**WEST SUSSEX COUNTY COUNCIL
PLANNING SERVICES CONSULTATION**

SUBJECT: Y/1/17/OUT-Outline Application with some matters reserved for the erection of 56No. dwellings with associated open space and creation of new access.

Bonhams Field, Main Road, Yapton, West Sussex, BN18 0DX

Revised Plans (SK02 L and N)

Appendix B: Proposed Master Plan

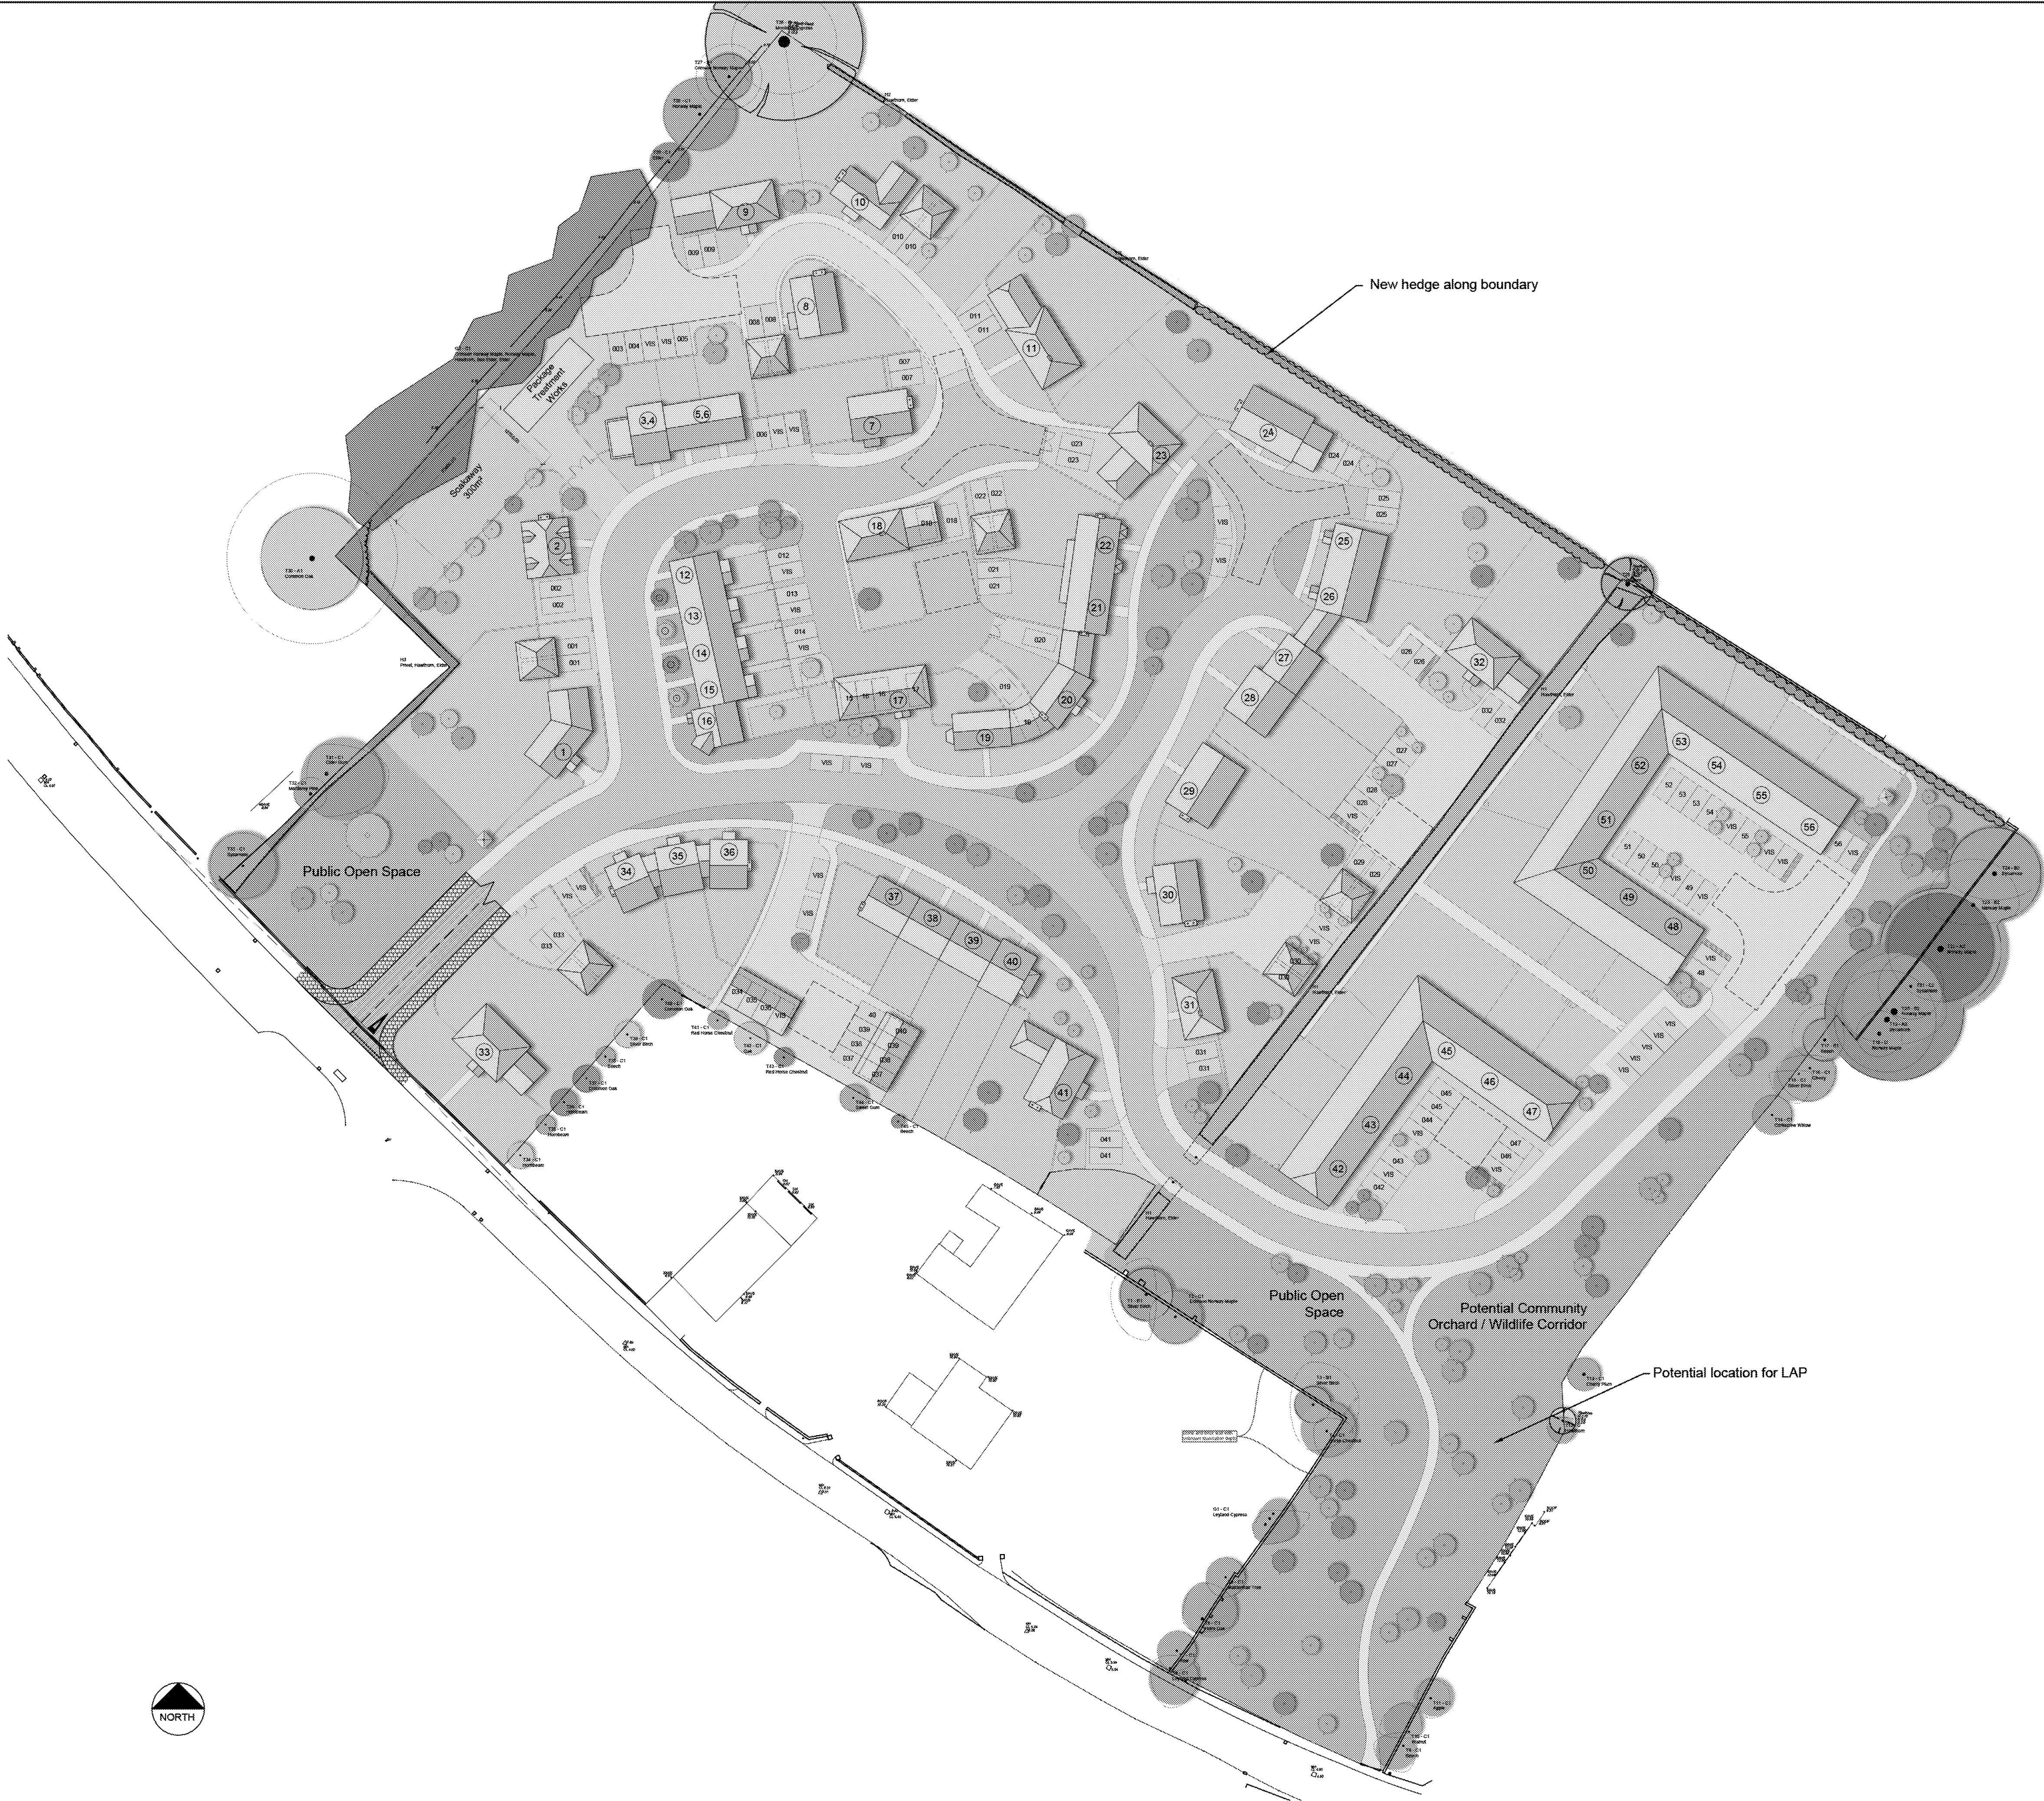
A revised layout has been submitted. The LHA has reviewed the two plans and whilst it is acknowledged that the plan will be subject a Reserved Matters application the LHA would draw the applicant's attention to the surface of the access road as 'Resin Bound Gravel'. If the estate road is to be adopted under a Section 38 Agreement with WSCC it is unlikely that this surface would be accepted at detail design. If the estate road is to remain private we are satisfied that it can stay in as proposed on the plans. In line with the previous advice the LHA would advise that the internal layout is designed in accordance with Manual for Streets (MfS) parameters.
